Development Control  
Ribble Valley Borough Council

**App no: 22.1039**

**Address: Land adjacent to 115 Kemple View Clitheroe**

**Proposal: Proposed construction of two new detached dwellings with associated access and garden areas. Resubmission of 3/2021/1263**

PROPOSED SITE PLAN

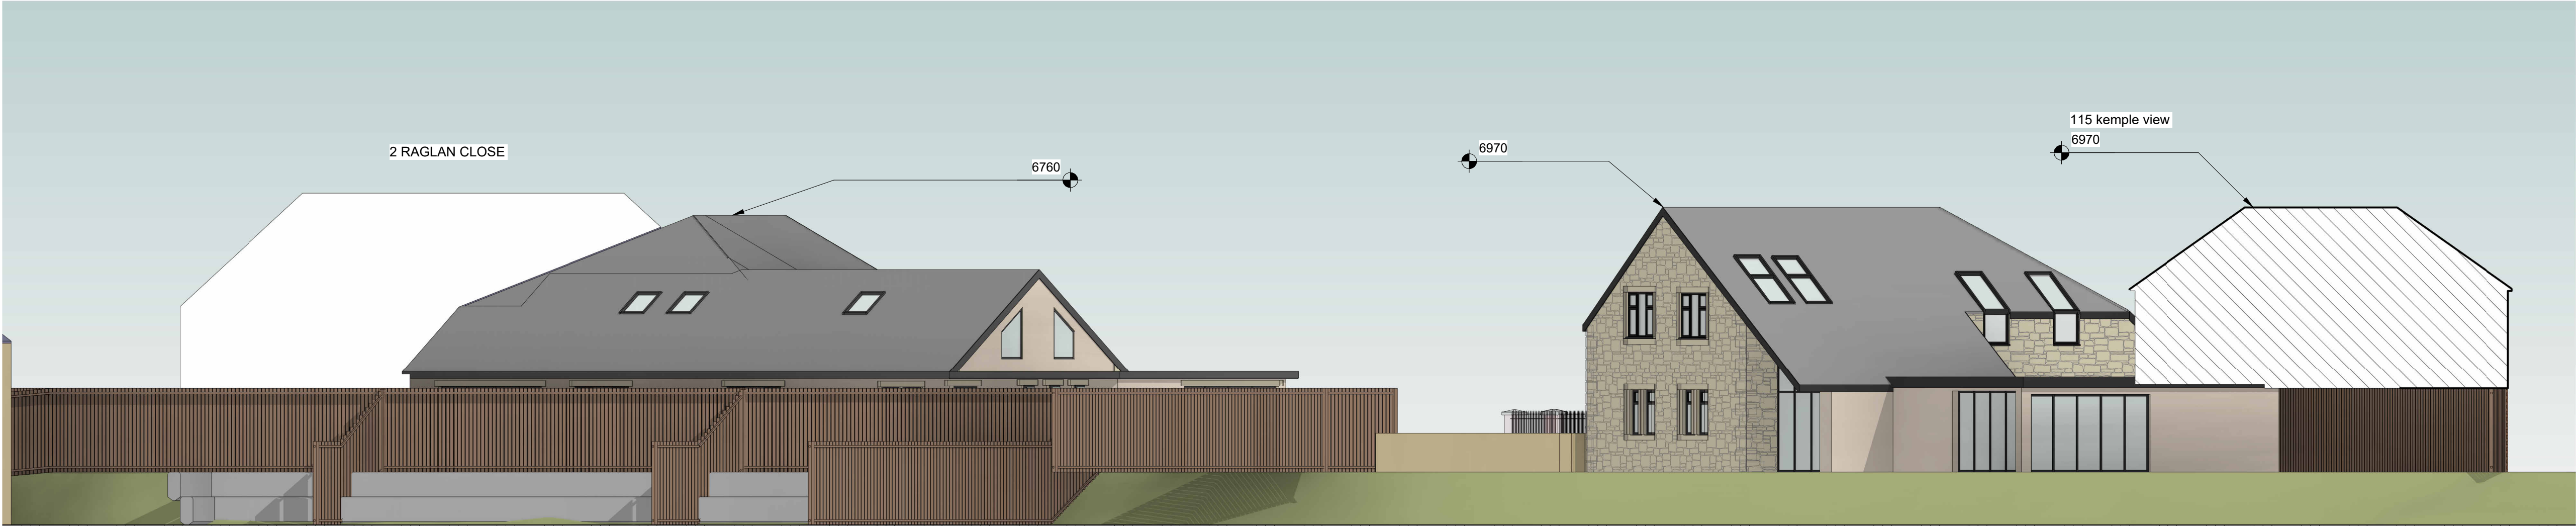
The level of car parking and turning areas are considered acceptable.

4. Prior to the first occupation of any dwelling, the car parking and turning areas shall be provided and maintained thereafter for the purposes of vehicle parking.

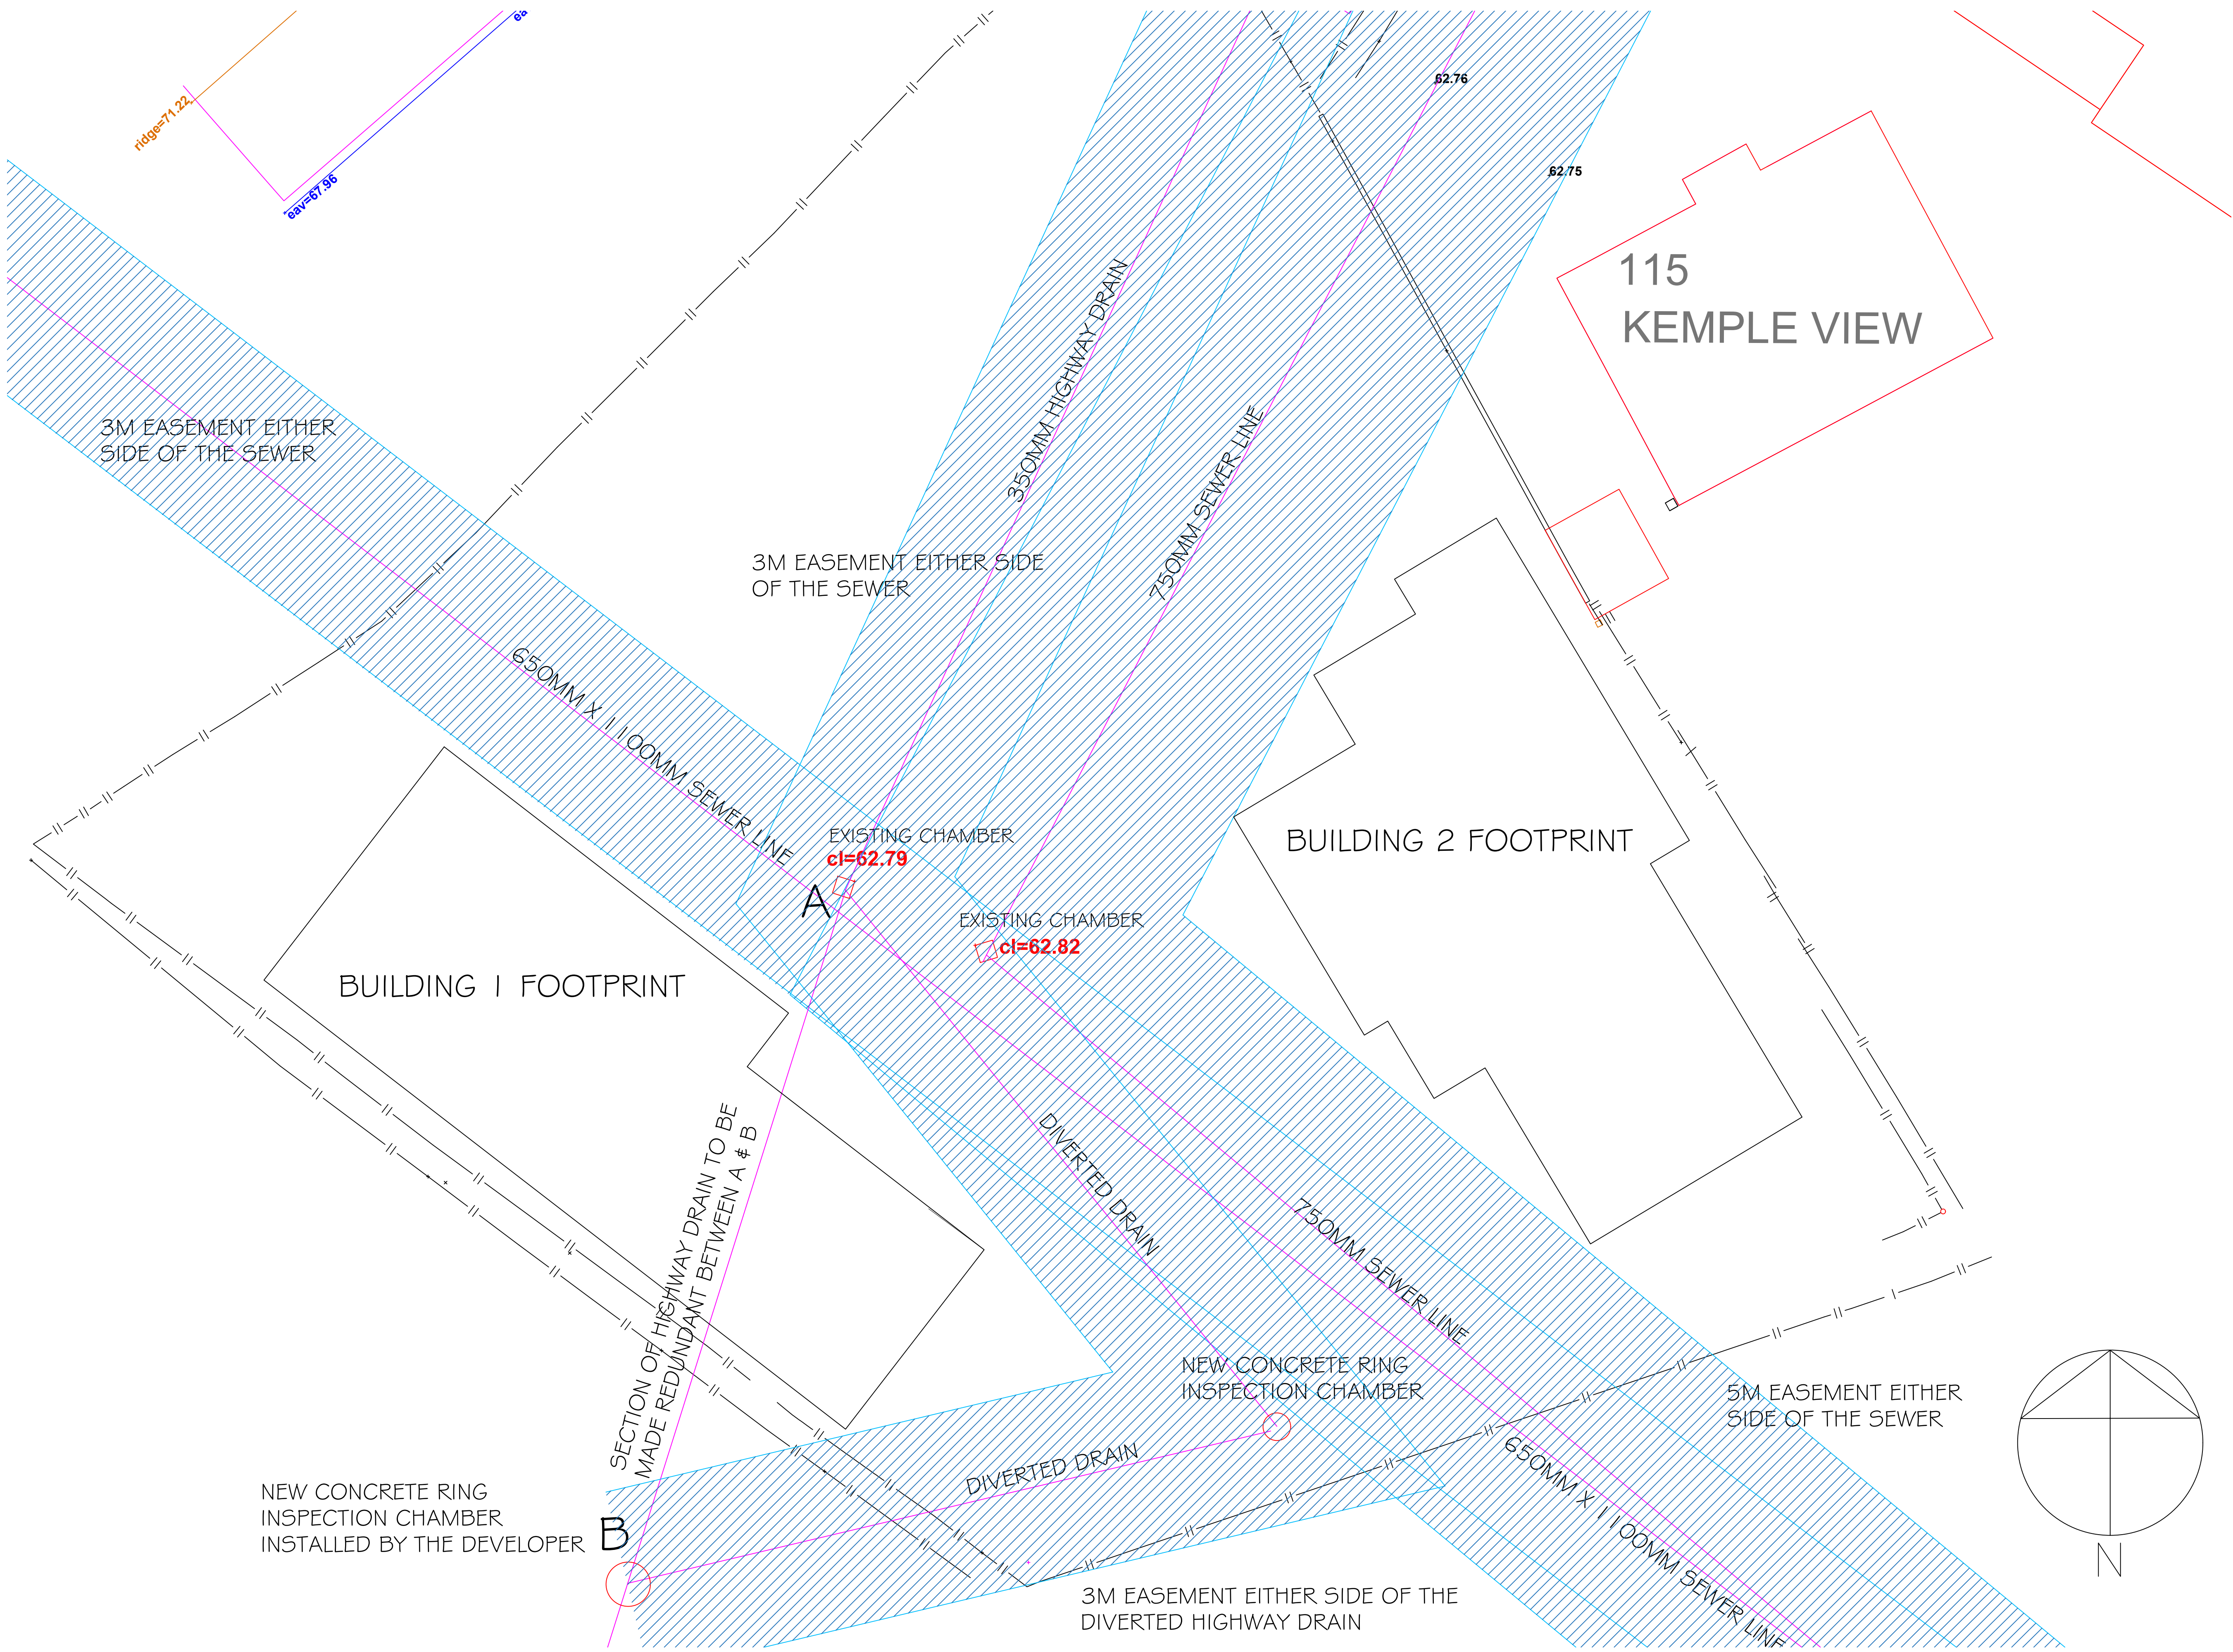
The proposed highway drain diversion shown on drawing 'Site drainage diversion and proposed building outline' PHA/366-100 is acceptable.

2. Prior to commencement of any building works, the drainage diversion works shown on drawing 'Site drainage diversion and proposed building outline' PHA/366-100 shall be completed in accordance with Lancashire County Council Specification under an appropriate agreement with access rights agreed thereafter.
